REQUEST

Current Zoning: N1-B (neighborhood 1-B)
Proposed Zoning: R-8MF(CD) (single family residential, conditional)

Approximately 15.93 acres located on the west side of Milhaven Lane, south of Juniper Drive, and east of Interstate 77.

The petition proposes a residential community containing a maximum of 90 single-family attached dwelling units.

CONCEPTUAL SITE PLAN
REZONING PETITION #2022-218

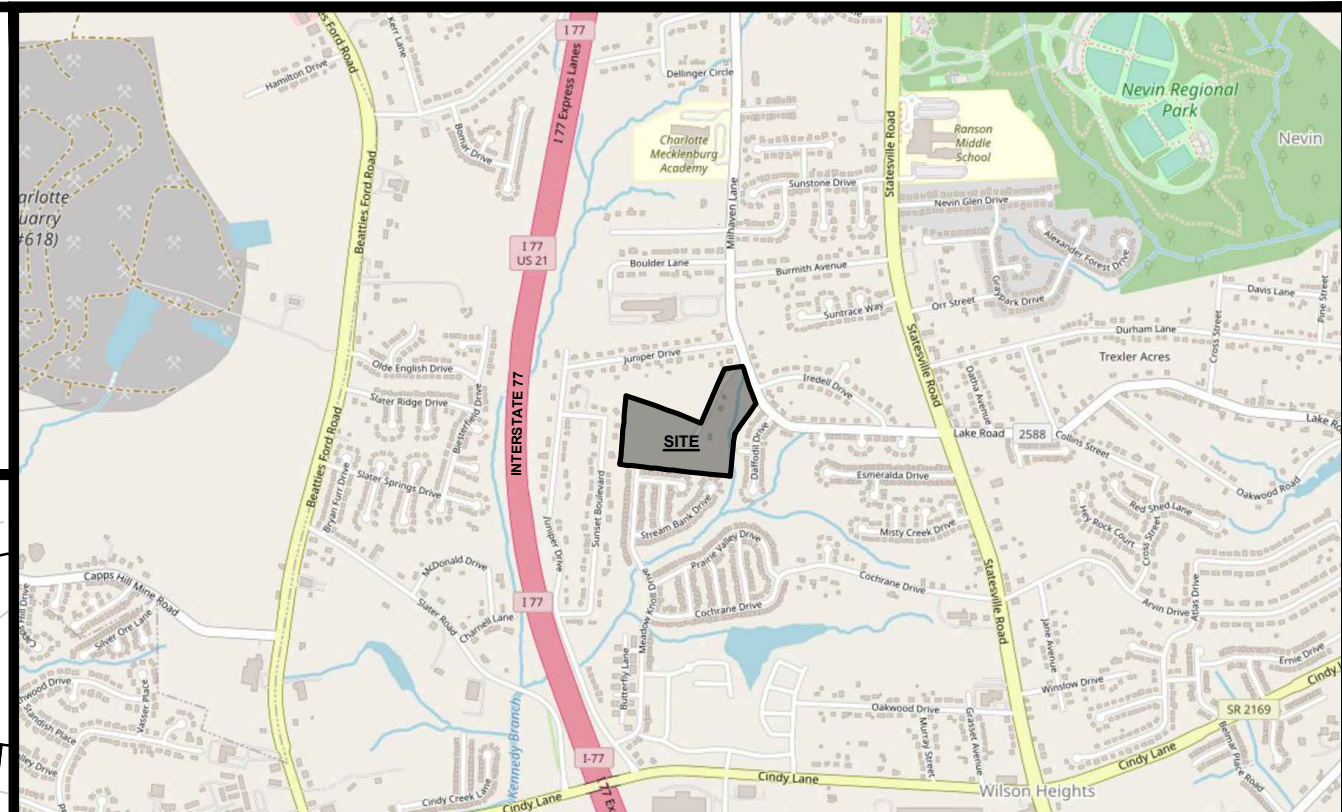
1. ~~Label and dimension 8-foot planting strip and 5-foot sidewalk along internal public streets.~~ Addressed
2. ~~Revise notes to say transportation improvements will be approved and constructed before the site's first building CO instead of 25th CO.~~ Addressed
